Our ref: HE551507-MMSJV-LSI-000-CO-UU-0004

30 April 2019

A303 Sparkford to Ilchester Dualling Development Consent Order - Non-material change request

Drawing Title: **WORKS PLANS REGULATION 5(2)(j) SHEET 1 OF 4**

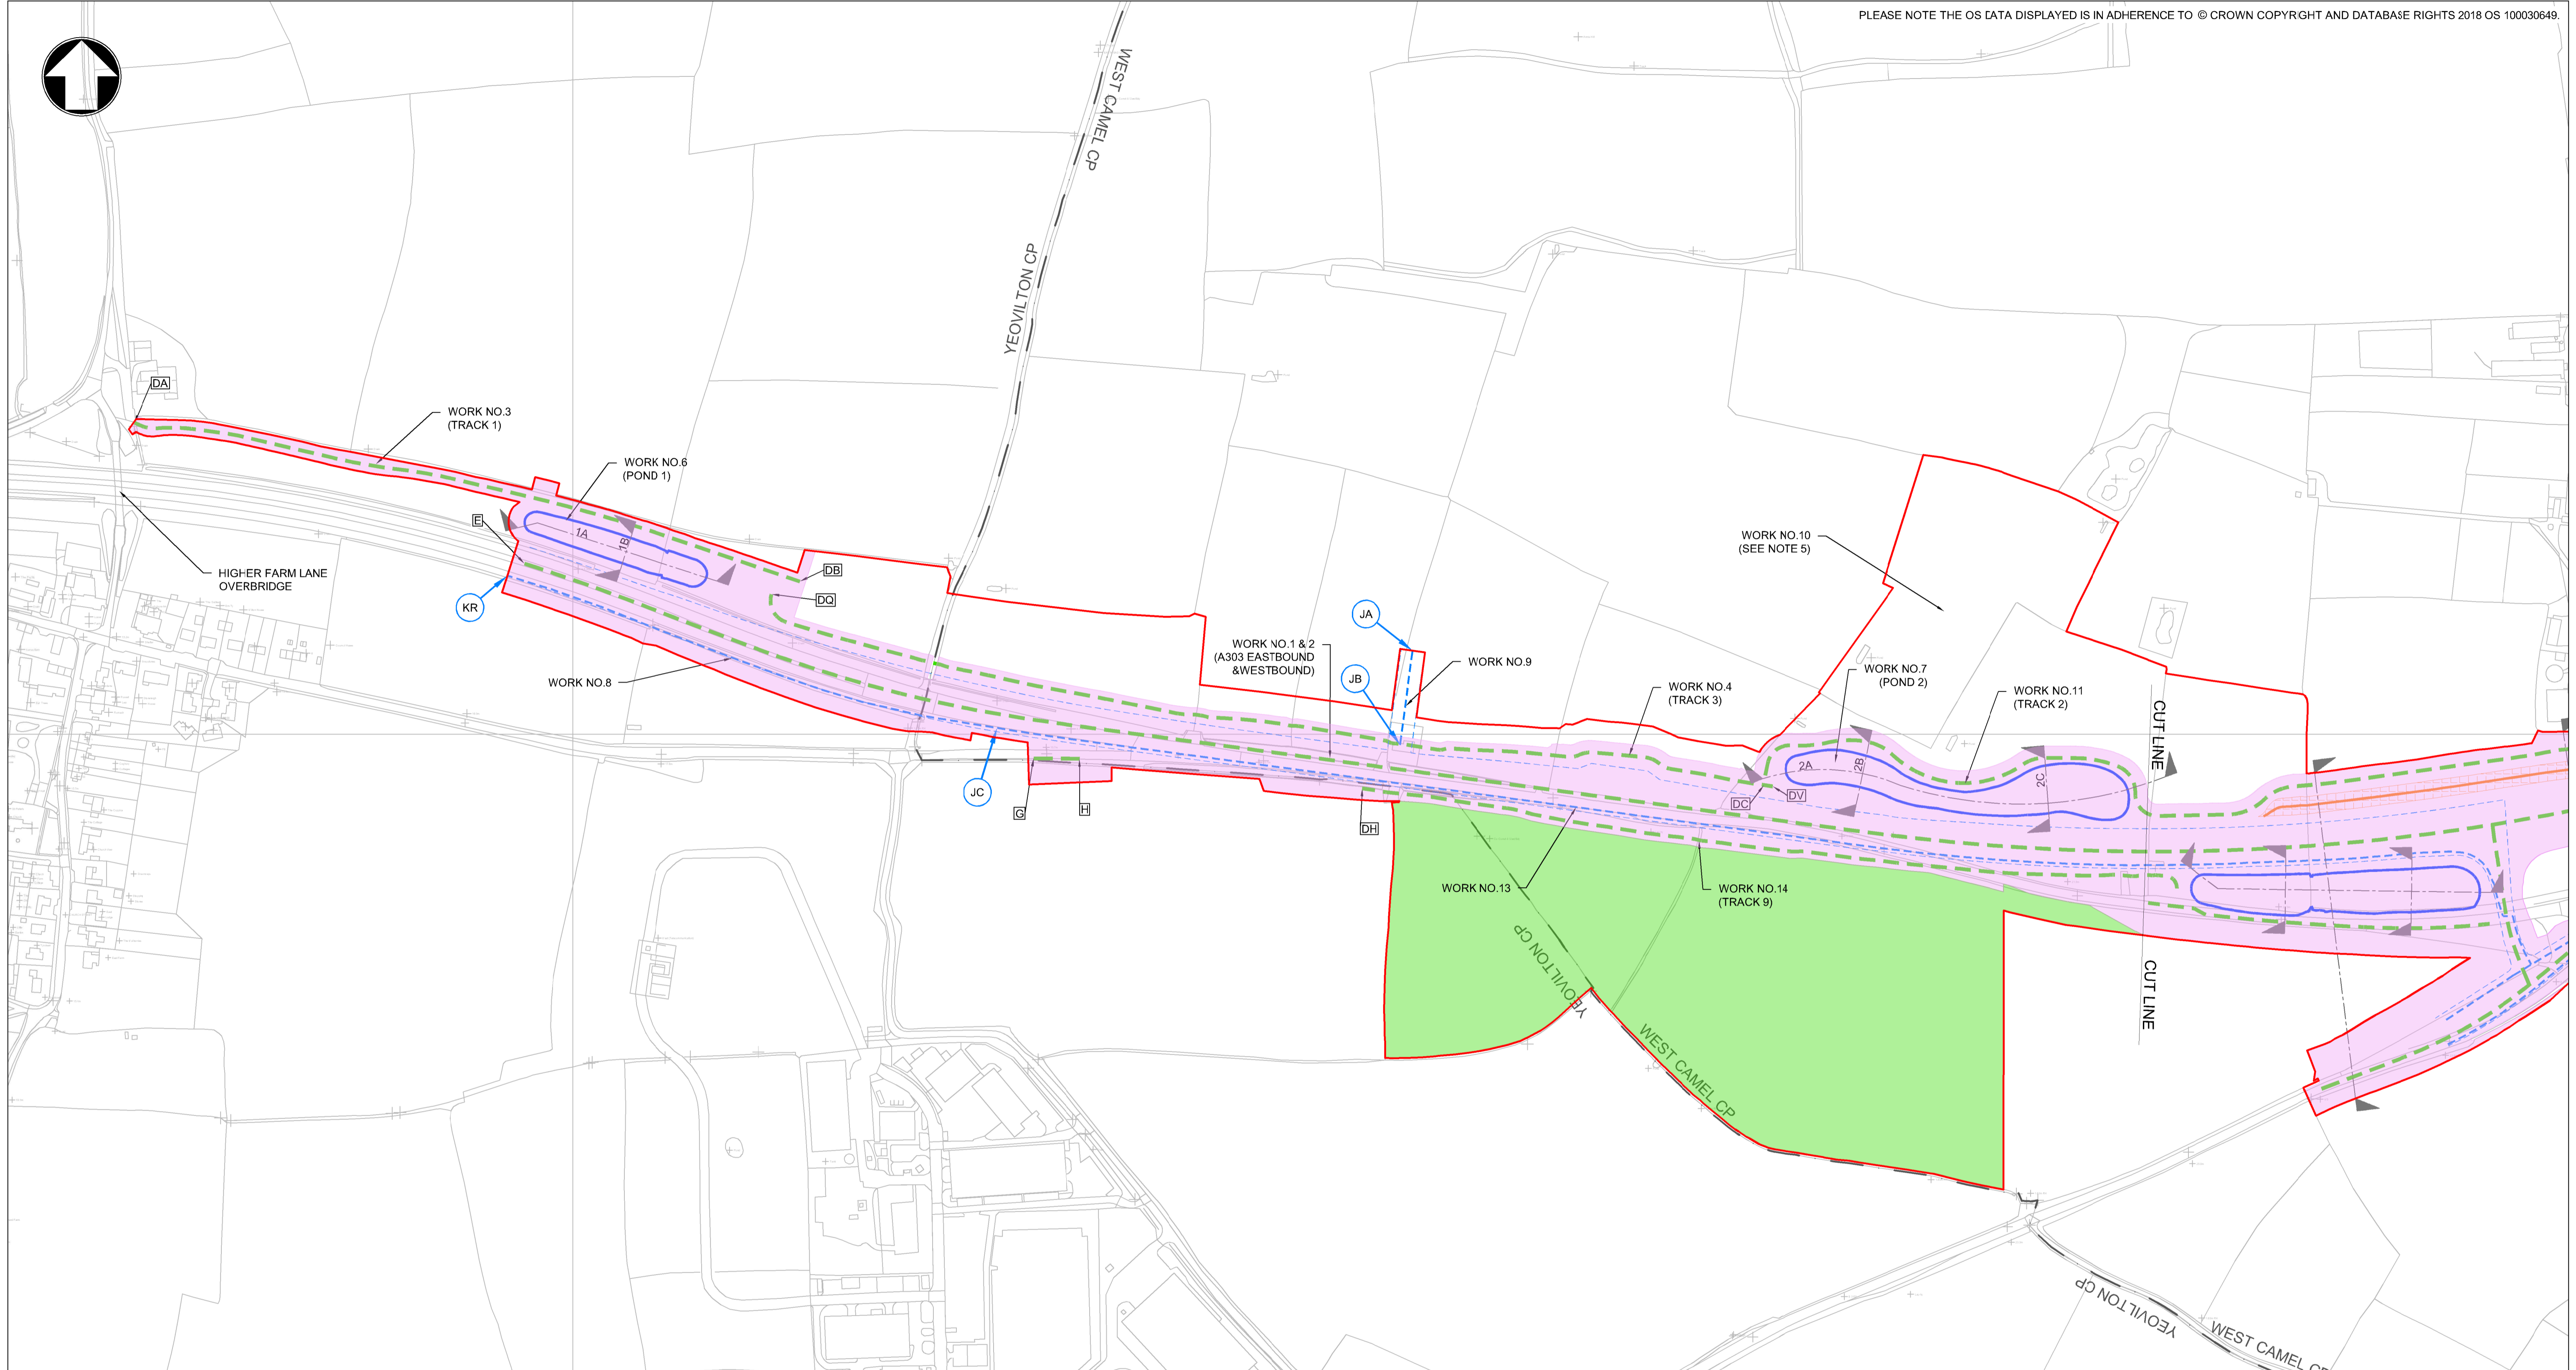
Following discussion with Somerset County Council, it was determined that there was no apparent need for a turning head in this location. This area of land (plot 1/5a) is therefore proposed to be downgraded to temporary possession only and no turning head is proposed in this location. This is shown on the enclosed Works Plans (Sheet 1). Somerset County Council requested this change and are therefore in support.

Drawing Title
**WORKS PLANS
REGULATION 5(2)(j)
SHEET 3 OF 4**

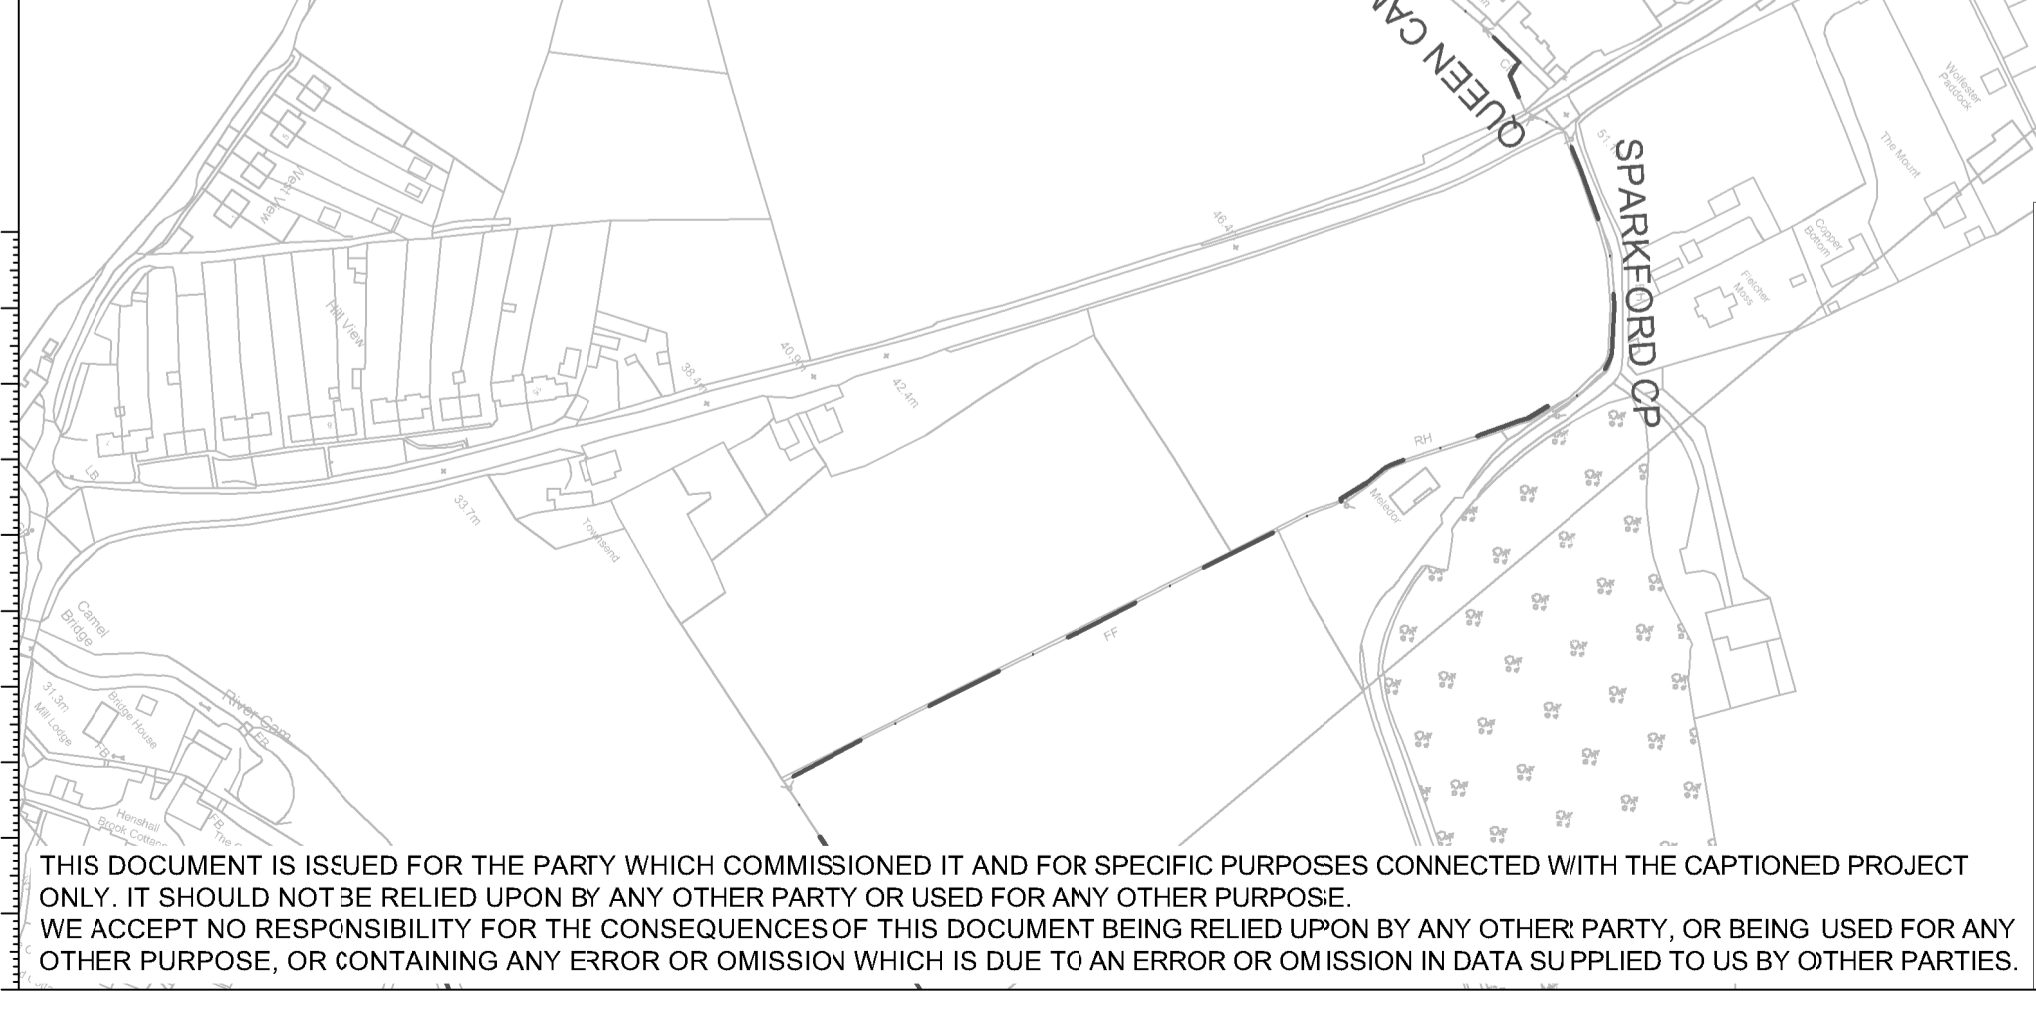
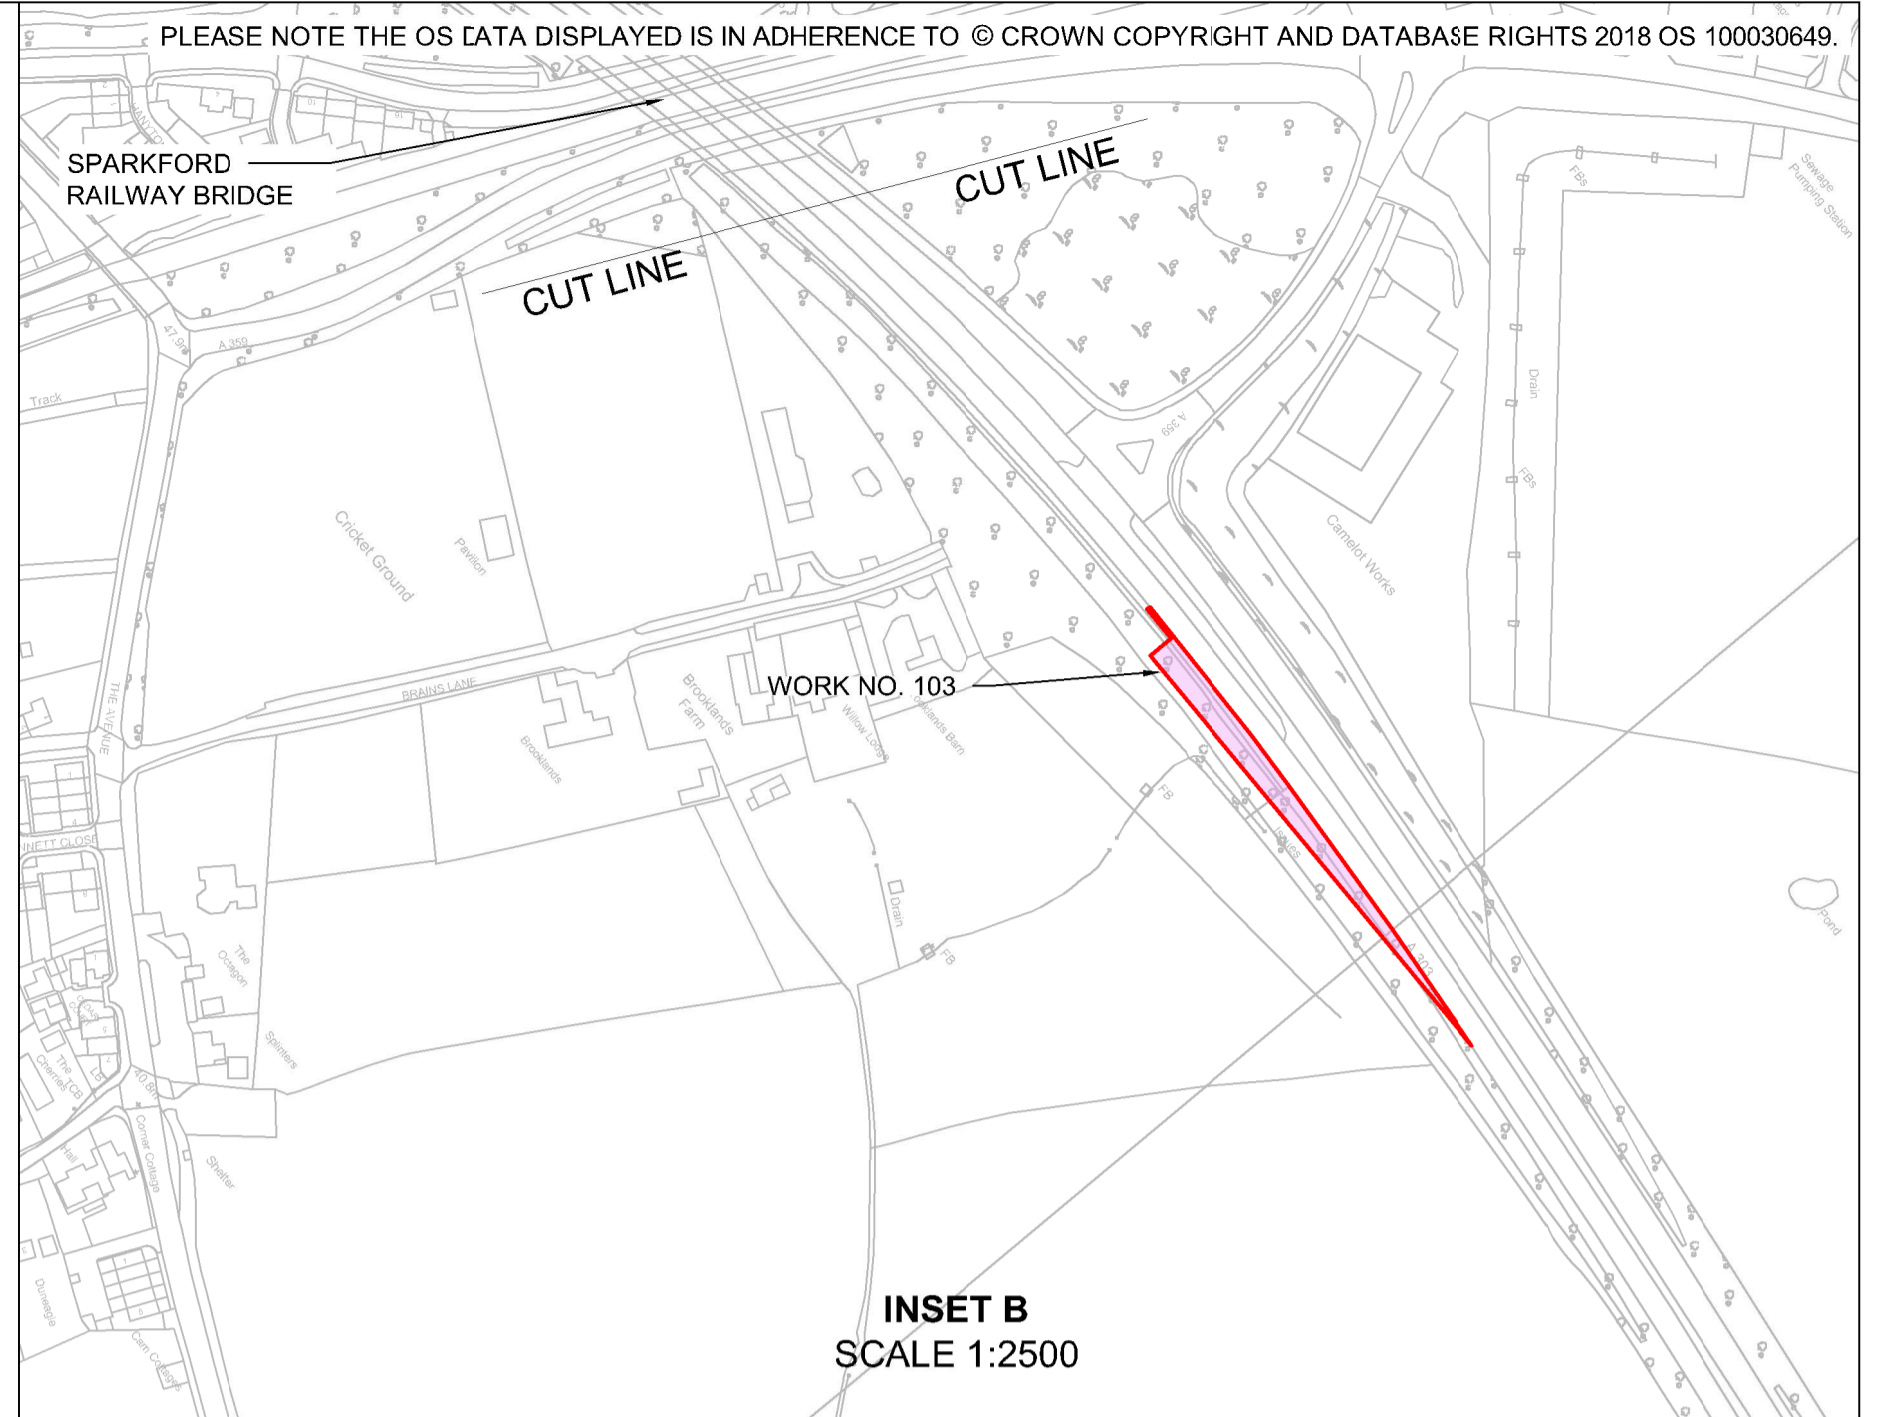
The Applicant had previously included two possibilities within the DCO for the diversion of the public right of way from the east of Traits Lane to the west of Gason Lane. One of these (shown as plots 7/5a and 7/6a on the Lands Plans (Sheet 7) [Drawing No HE551507-MMSJV-LSI-000-DR-UU-2023, REP5-002]) was located on Crown land, owned by the DIO and the other (shown as plots 7/7a and 7/7c on the Lands Plans (Sheet 7)) [Drawing No HE551507-MMSJV-LSI-000-DR-UU-2023, REP5-002]) was located on land owned by Mr Hewlett.

Therefore, the Applicant now proposes using the Crown land. This avoids taking land from Mr Hewlett which includes a memorial garden that has a particular significance to the Hewlett family. This is shown on the enclosed Works Plans (sheet 3).
